RE: 1 Industrial Way- Foundation Brewery

From: Barbara Barhydt [mailto:bab@portlandmaine.gov]**Sent:** Tuesday, June 07, 2016 8:32 AM**To:** Mike Hays <mike@GRANTHAYS.COM>**Cc:** Tina Bonney <tina@foundationbrew.com>; John Bonney <john@foundationbrew.com>; Munson, Jennifer <jmy@portlandmaine.gov>; Bourke, Jeanie <jmb@portlandmaine.gov>; Leader, Laurie <lrl@portlandmaine.gov>; Stacey, Christina <cstacey@portlandmaine.gov>; Machado, Ann <amachado@portlandmaine.gov>**Subject:** Re: 1 Industrial Way- Foundation Brewery

Subject: 1 Industrial Way- Foundation Brewery

Drawing file: 1. Original Plans / Site Plan.pdf

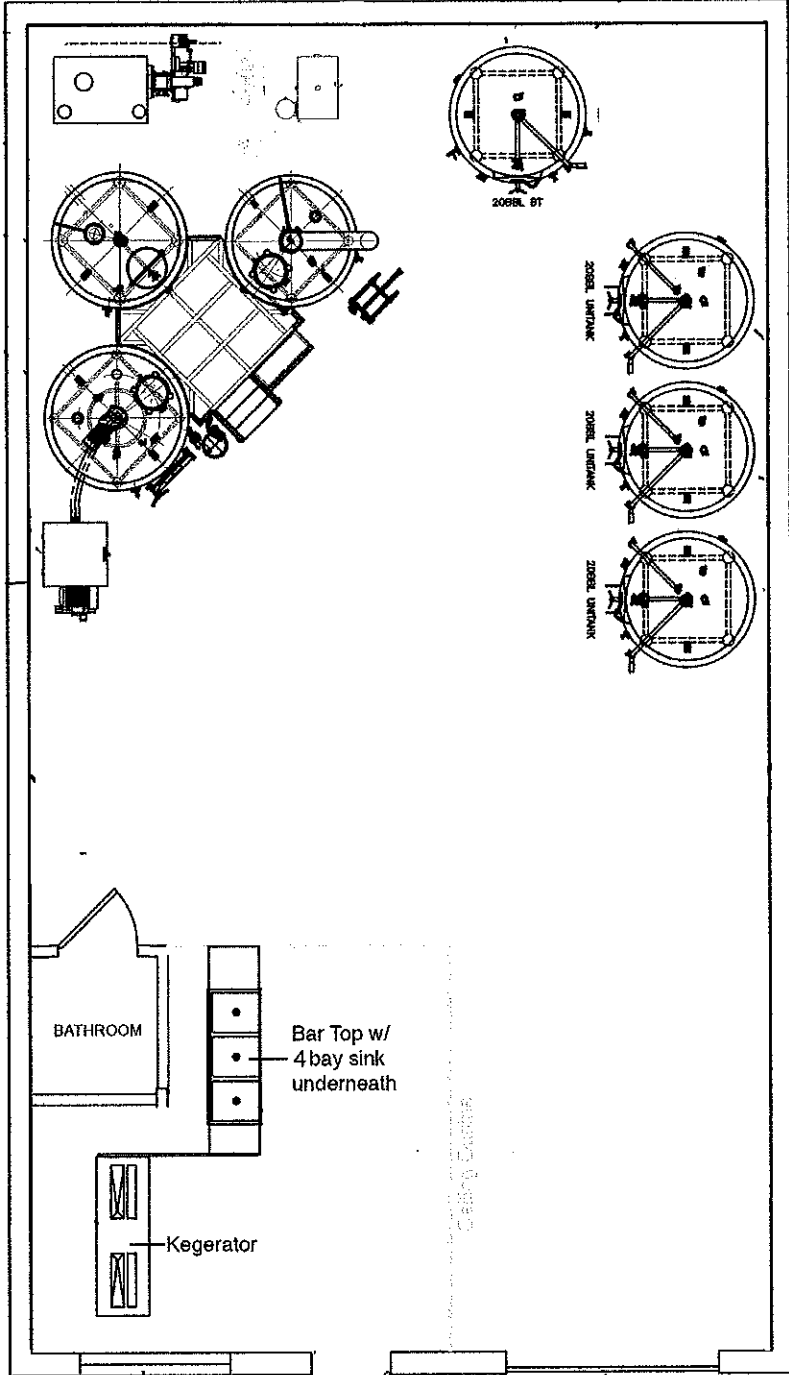
We looked at the plans yesterday and Jeff Tarling speculated that a tree would be lost. He suggested that the 3rd one be removed and then do other screening, such as the fencing and landscaping you are proposing. Can you put your proposal on the site plan and give a detail for the fencing?

I presented the administrative authorization at the development review meeting on Wednesday. Several questions were raised. First, could those chillers be located elsewhere on the site and not adjacent to a public sidewalk? Secondly, the aerial shows trees along the Riverside frontage for screening. How does this proposal impact the screening? Lastly, the maximum allowable noise level is 70 db between 7 a.m. and 10 pm.m and then it lowers to 55 dba. The material you sent says the level will be 60 dba from 10 feet away. Is there any noise attenuation proposed to meet the night time levels?

Jeff looked at the plans and he is satisfied with the plan as revised. Attached is my sign off on the administrative authorization. Please note that there are three conditions of approval. One is to install the screening as shown and preserve the 4 trees. Two is to obtain all required building permits. Three is to include noise mitigation measures if the noise levels of the condenser exceed the zoning standard.

Attached is the revised site plan indicating the condenser pad & fence location, as well as the plantings.

The fence would be constructed of white cedar vertical boards, square top, with square 6x6 white cedar corner posts. The fence would be solid (no gaps). The fence would be 5' x 10' in plan; 6' tall.

The plantings would be 5 upright arborvitae to screen the fence from the street.
